Application no: H08/0537/00

**Description:** Change of use and alterations  
to provide a development/test  
kitchen, offices, taste panel  
room and storage area

**Amendment:** Fencing extended to enclose car parking area  
Dwg. no. C01D

**NOTICE OF ACCEPTANCE OF AMENDMENT**

Rev.	Description
D	Fence extended to end of car park
Date	06.12.00

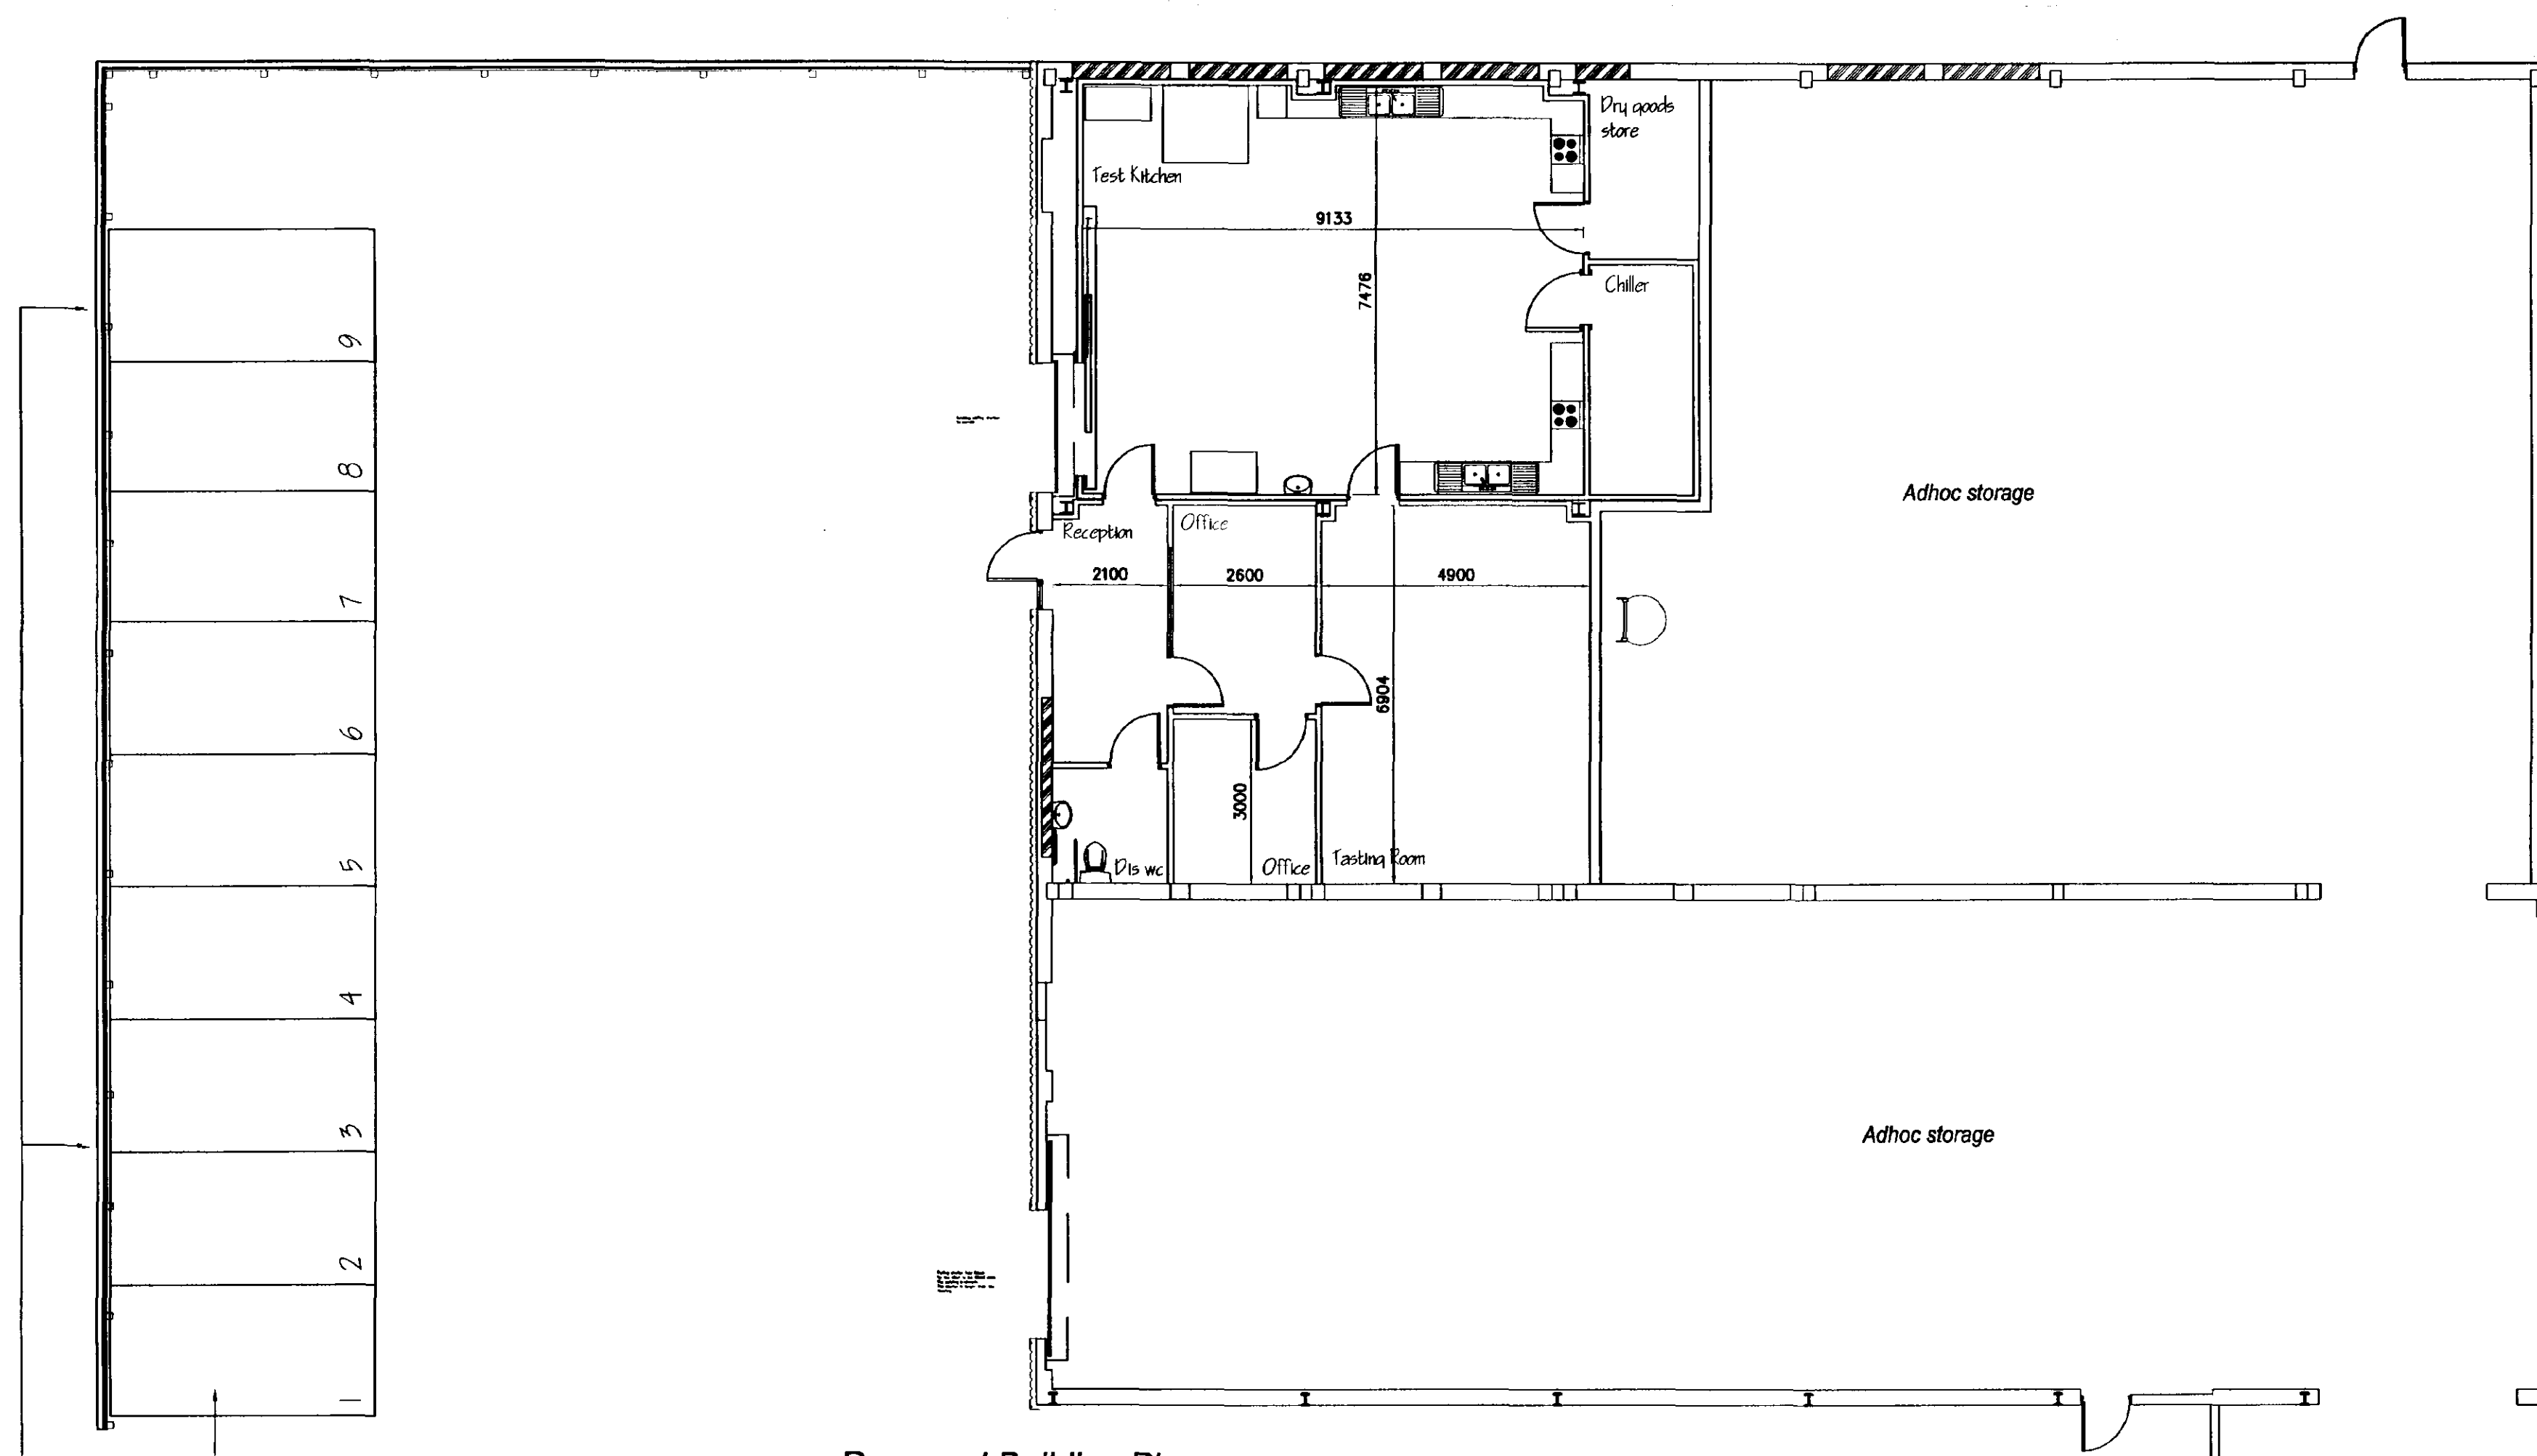
The client has extended the fencing to enclose the car parking area outside the above development.

Fencing Extended to enclose car Parking Area

The amended details submitted in respect of the above proposal have now been considered and there are no objections to the amendment being implemented to the extent described above.
